NUEVO ATRISCO | MAJOR SITE PLAN AMENDMENT DRB COMMENT RESPONSES

NUEVO ATRISCO DRB Comment 6.24.2022 Responses					
Commenting Agency	Action	Date Received	Comment	Applicant Response	Applicable sheets
NMDOT	PR-2018-001405 Site Plan PR-2020-003847 Plat	6.24.2022	NMDOT does not have any comments at this time	No response necessary	-
AMAFCA	PR-2020-003847 Plat	6.24.2022	No adverse comments	No response necessary	-
MRMPO	PR-2018-001405 Site Plan	6.24.2022	MRMPO has no adverse comments	No response necessary	-
	PR-2020-003847 Plat	6.24.2022	MRMPO has no adverse comments.	No response necessary	-
ABCWUA	PR-2018-001405 Site Plan	6.24.2022	Availability Statement #211219 has been issued and provides the conditions for service. The availability statement indicated a fire flow of 1,725 gpm whereas the provided fire one plan in the DRB submittal indicated a fire flow of 2,000 gpm. Please confirm. A new request for availability may be required to account for the increase in fire flow.	Civil is coordinating with ABCWUA and has submitted a new water availability statement

PR-2018-001405 Case Description: Amendment to Site Plan | SD-2022-01115, VA-2022-00165 Sidewalk Wavier | PR-2020-003847 Case Descr

SHEET NO.
SDP2.1

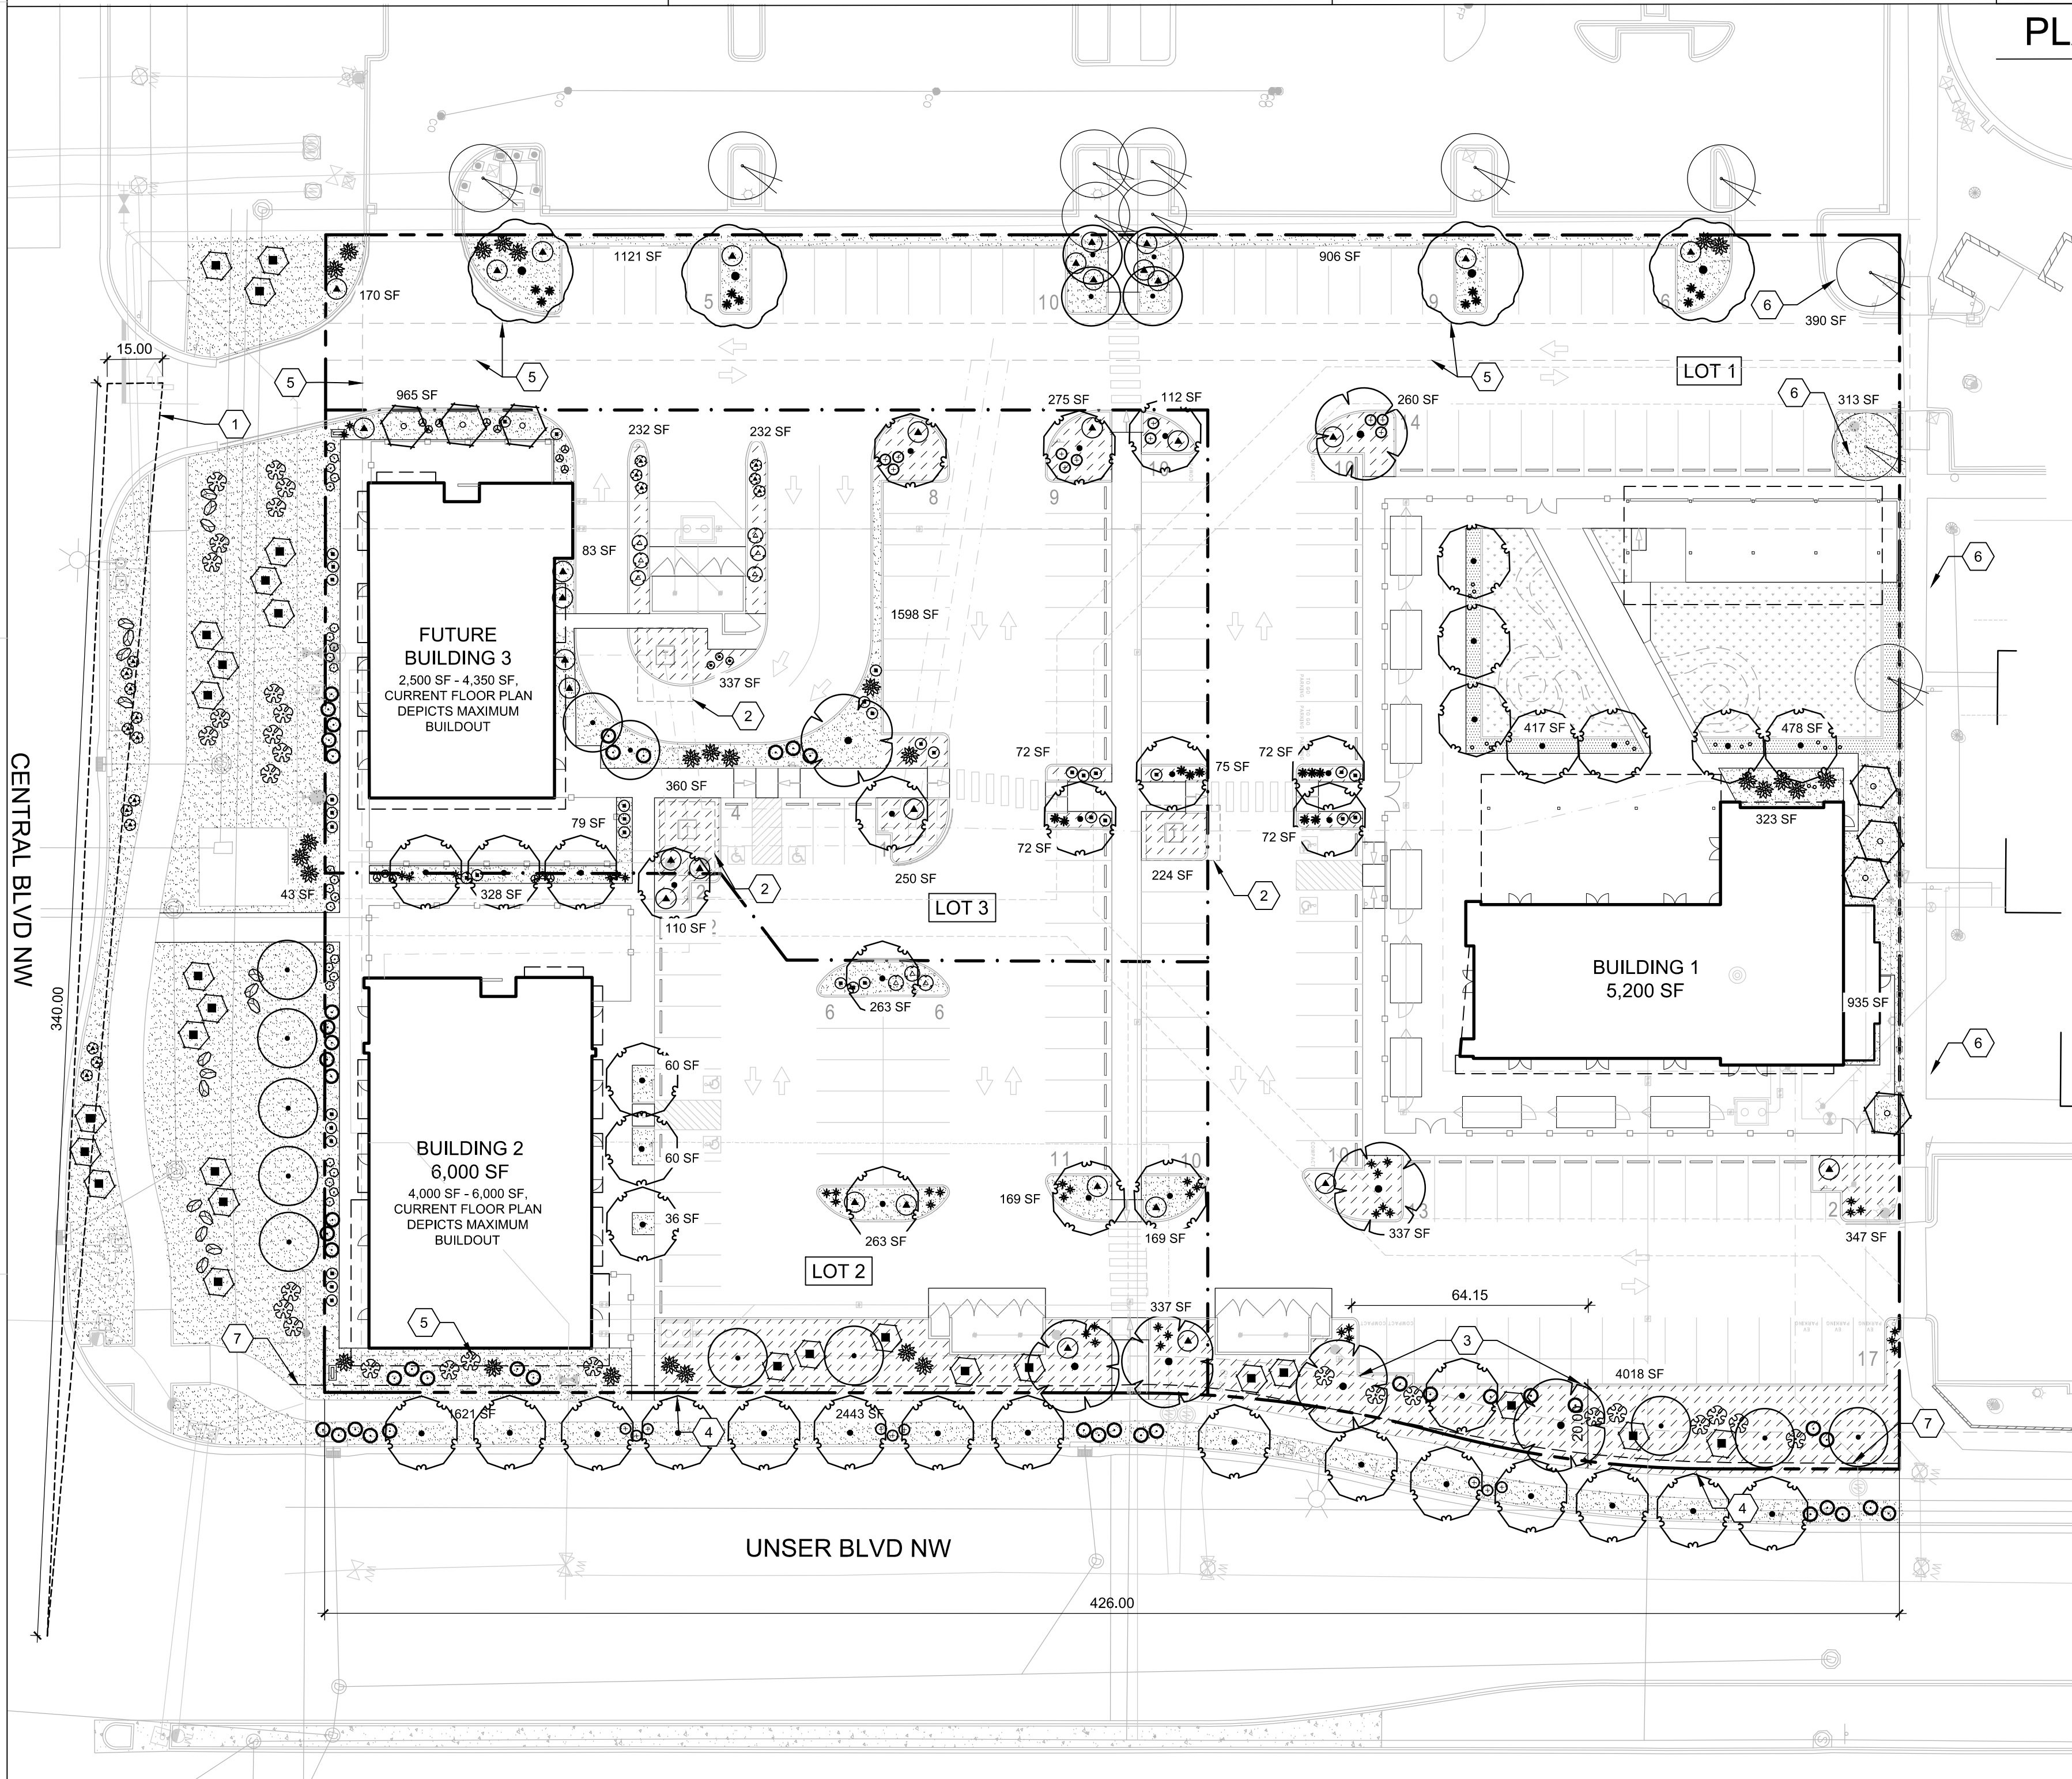
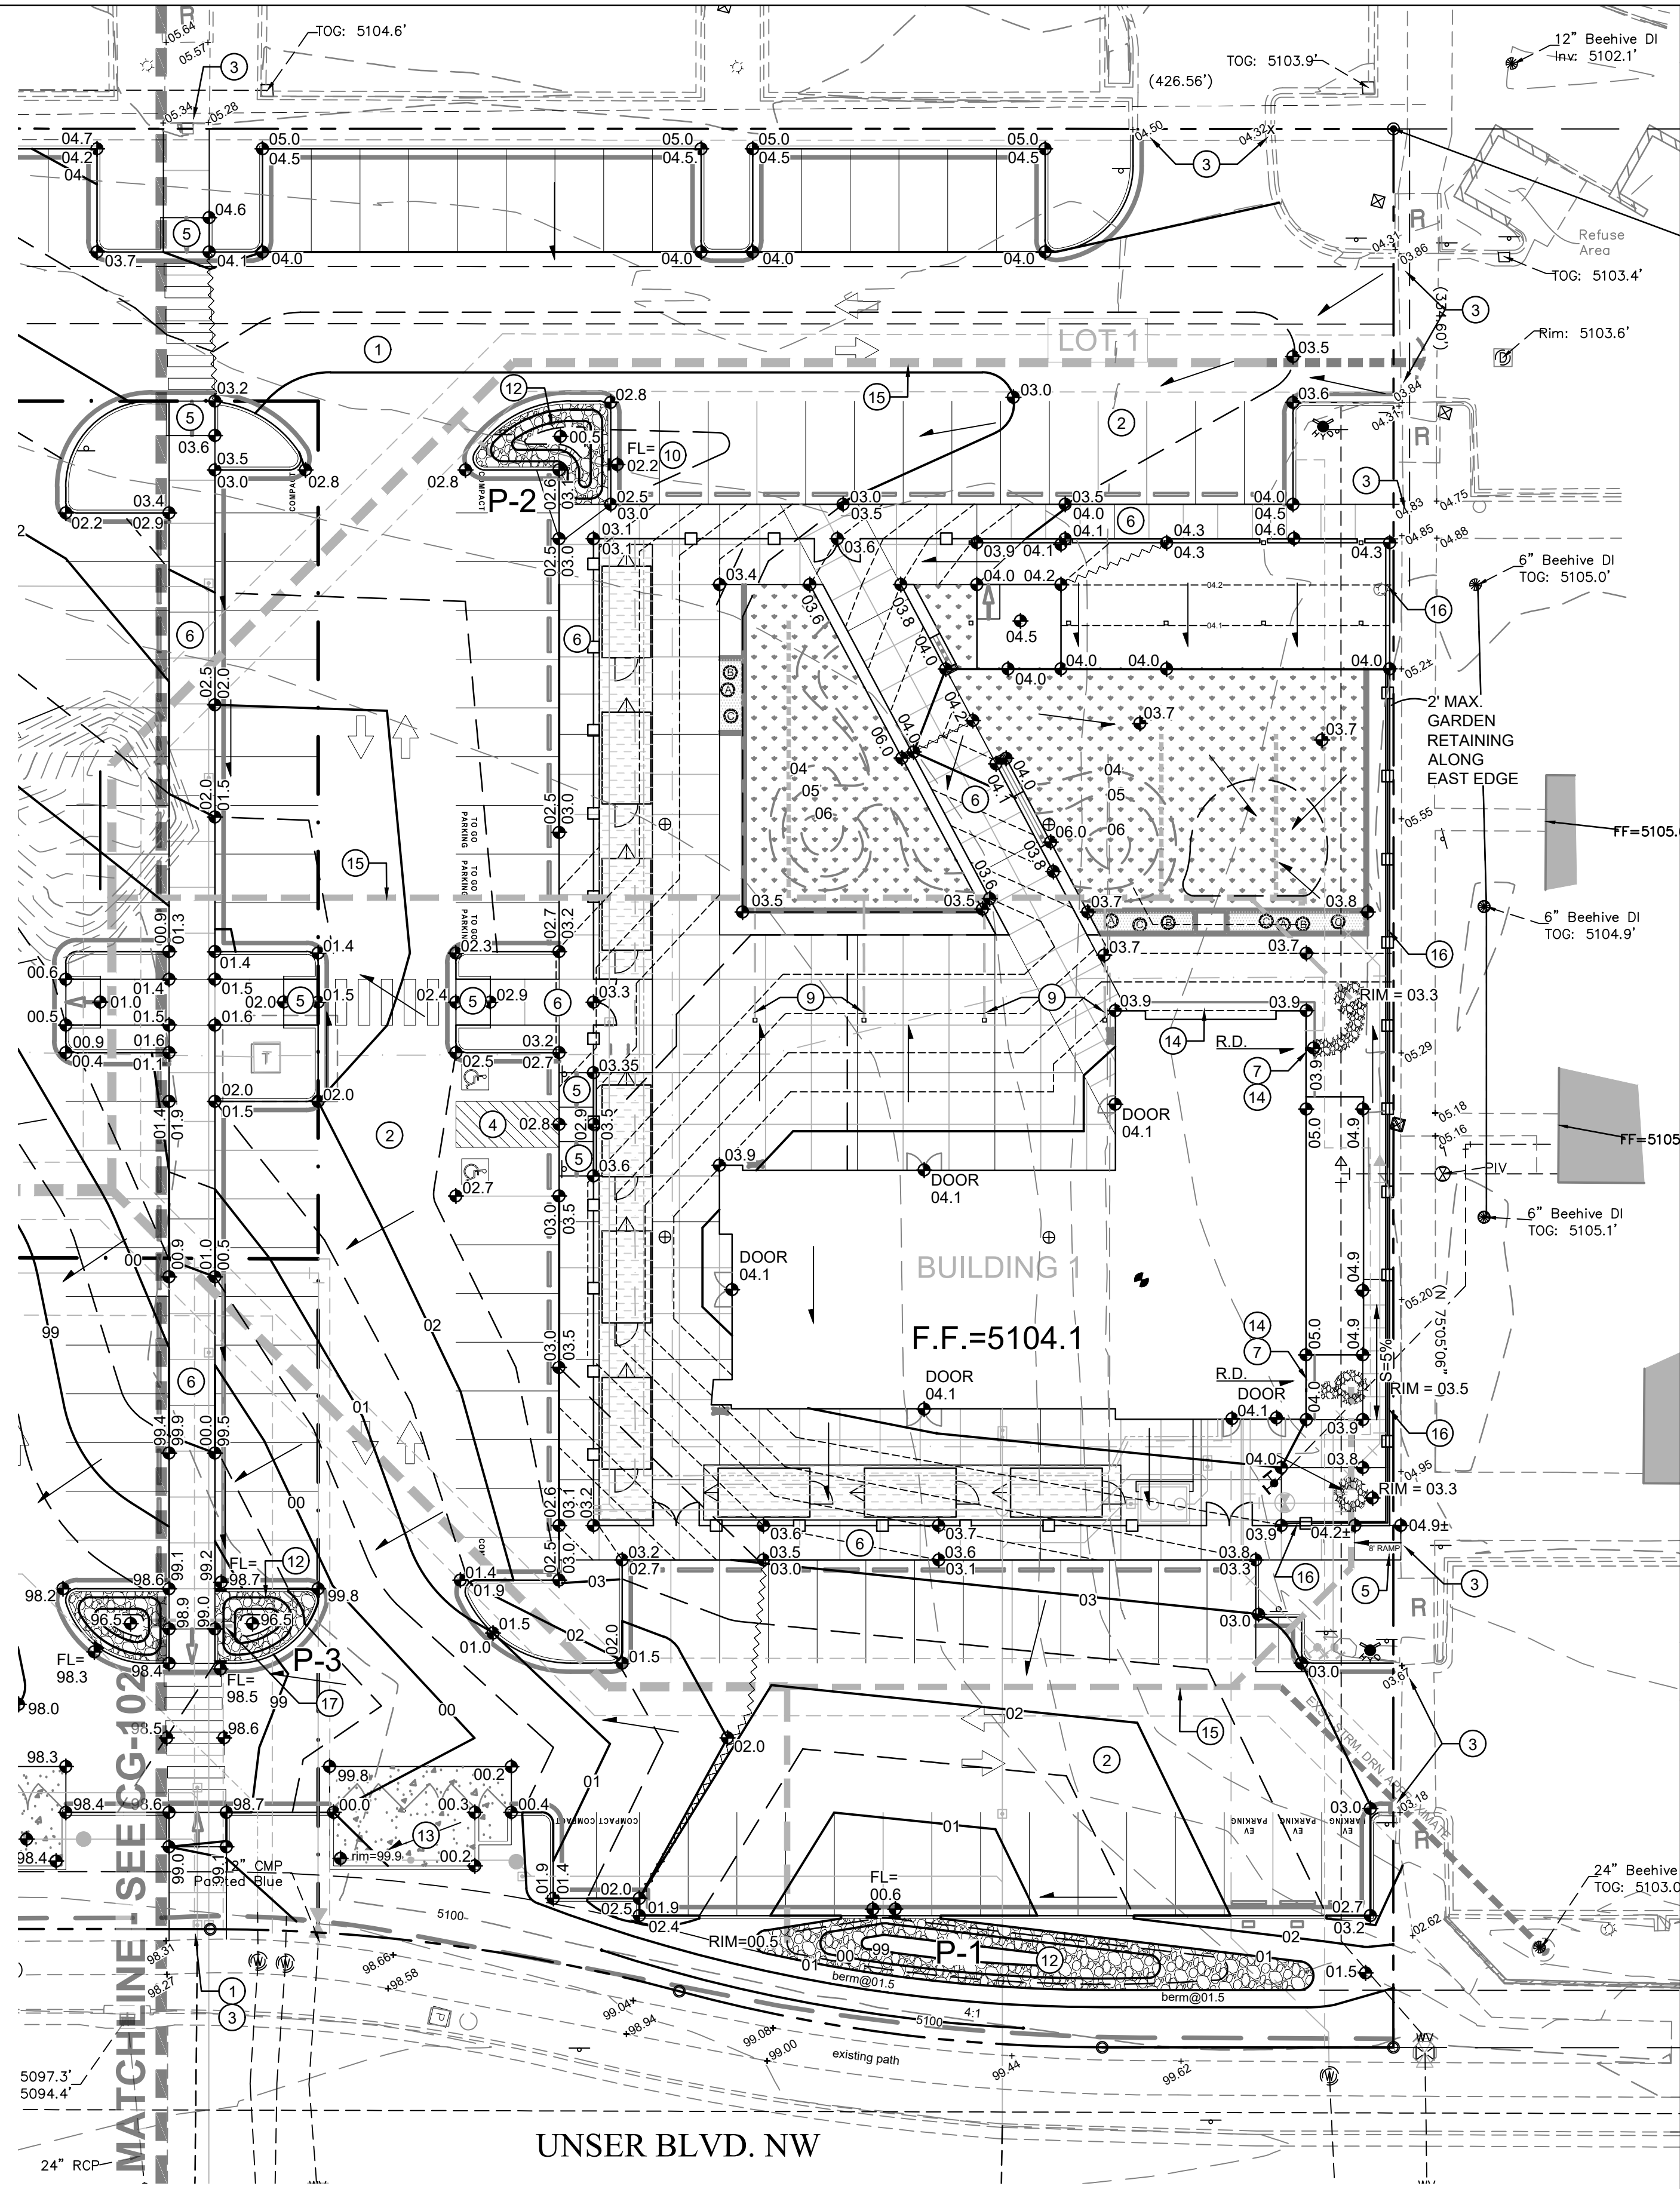
Parks and Rec	PR-2018-001405 Site Plan	6.24.2022	The Urbanite Ash is not a recommended tree on the City's Official Plant Palette due to drought and heat stress. The Nature Conservancy's NM Climate Ready List may show additional options for the parking lot.	The submitted Landscape Plan SDP2.1 does not list Urbanite Ash as a proposed tree.	
Planning	PR-2018-001405 Site Plan	6.24.2022	The project and application numbers must be added to Plat sheets, prior to final sign-off from Planning.	The project team will reflect the accurate project numbers on all sheets resubmitted to DRB staff for final sign-off.	
Planning	PR-2018-001405 Site Plan	6.24.2022	Utility signatures, AMAFCA signatures and DXF File approval from AGIS will be required for the Preliminary and/or Final Plat actions. Those signatures must be obtained and included with all submittals prior to the acceptance of that application and the placement on a DRB agenda

Planning	PR-2018-001405 Site Plan	6.24.2022	No Landscape Plan sheet is included with the Major Site Plan Amendment – DRB submittal, but an Alternative Landscape Plan is mentioned in the justification letter. The Alternative Landscape Plan should be submitted to DRB. Any Alternative Landscape Plan must be approved prior to the approval of the Major Site Plan Amendment – DRB application.	The Site Plan amendment packet submitted on 6.3.2022 which can be retrieved utilizing this link (☐ Nuevo Atrisco - DRB Major SP Amendment Submittal 6.3.2022) included a landscape plan on page 161 of the pdf. No alternative landscape plan was deemed necessary.	SDP2.1
Planning	PR-2018-001405 Site Plan	6.24.2022	As part of landscaping plan: confirm compliance with 5-6(D)(2)(b) “Downtown, Urban Centers, and Main Street and Premium Transit areas. Fifty (50) percent of any front setback area not used for pedestrian access to the building or improved with pedestrian furniture and amenities shall be landscaped, and no part of the front setback area surface shall be asphalt.”	The applicant has added shrubs to the landscape strip to the south of the pedestrian path between the buildings and the property line along Central Avenue. The landscape coverage within this areas complies with the 50% percent requirement.	SDP2.1

Planning	PR-2018-001405 Site Plan	6.24.2022	Show compliance with 5-6(F)(1)(b) “Downtown, Urban Centers, and Main Street and Premium Transit Areas. Any parking lot located within 20 feet of a side or rear lot line shall be screened by a landscaped buffer	A 5' wide landscape buffer with the required ratio of trees and shrubs is provided along Unser Blvd., where required.	SDP2.1

Planning	PR-2018-001405 Site Plan	6.24.2022	<p>There is a row of trees on the existing Site Plan that provides some landscape buffer between the commercial and the multi-family. Please show how the proposed landscaping provides equivalent or better landscaped buffering to the multi-family development.</p> 	A landscape buffer is not required per Table 5-6-4. The applicant added additional trees as a buffer to the adjacent multi-family housing site.	SDP2.1
